## Planning Consultation Memo

Date	Planning Officer	Environmental Health Officer
20/09/18	William Myers	Karl Riahi
Planning Application Number	Worksheet Number	
6/2018/2092/FULL	WK/100983

**Address:** 8 Harpsfield Broadway Hatfield AL10 9TF

**Application Details:** Change of use from shop (A1) to ice cream/dessert parlour (A1/A3) and erection of single storey rear canopy seating area.

PROPOSED GROUND FLOOR PLAN

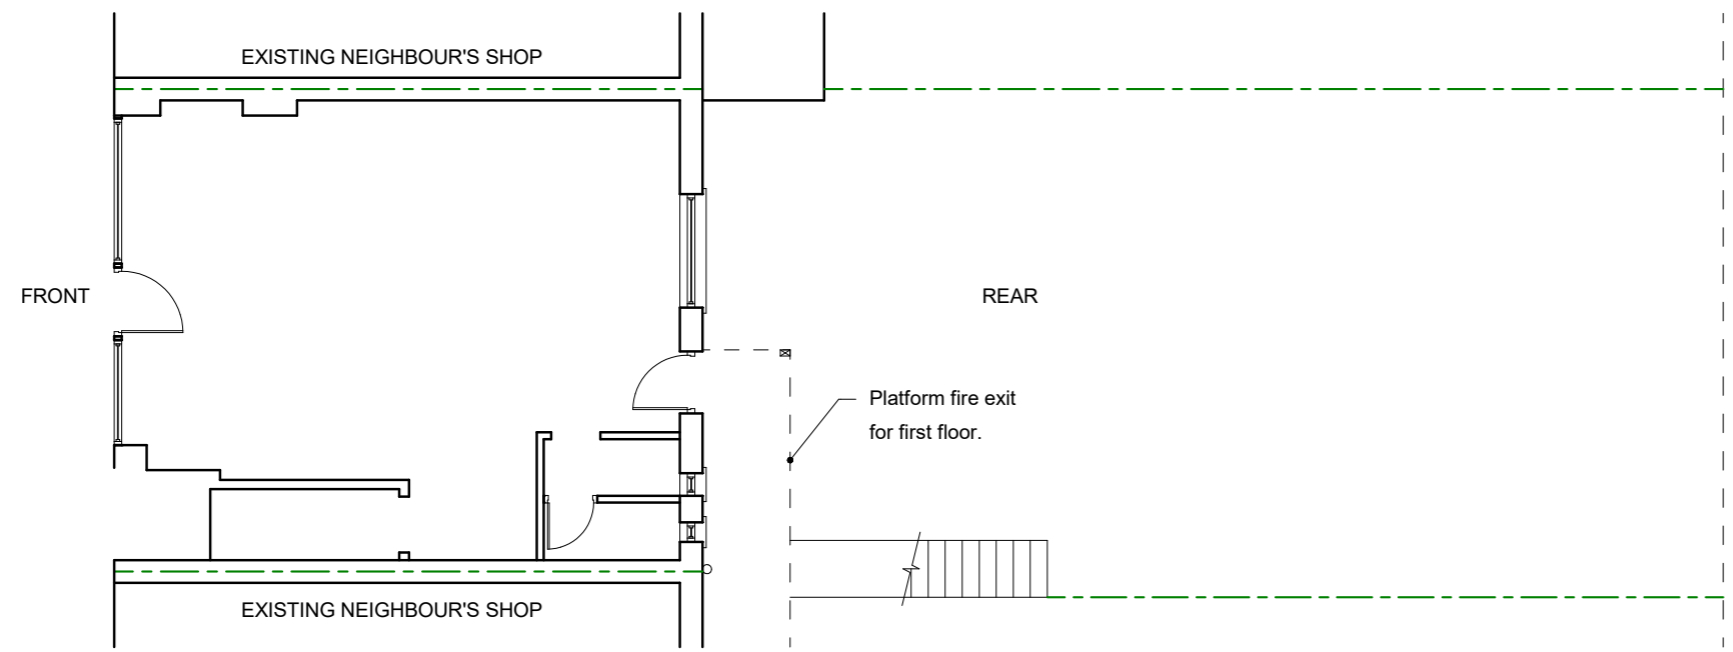
As per my previous response, the toilet will need a lobby area as it will be opening directly onto where food is to be prepared. It is important to raise this issue at this time as the applicant will then be able to alter the layout of the premises to facilitate this requirement. It would be likely that enforcement action is taken once the business begins to operate to secure this requirement.
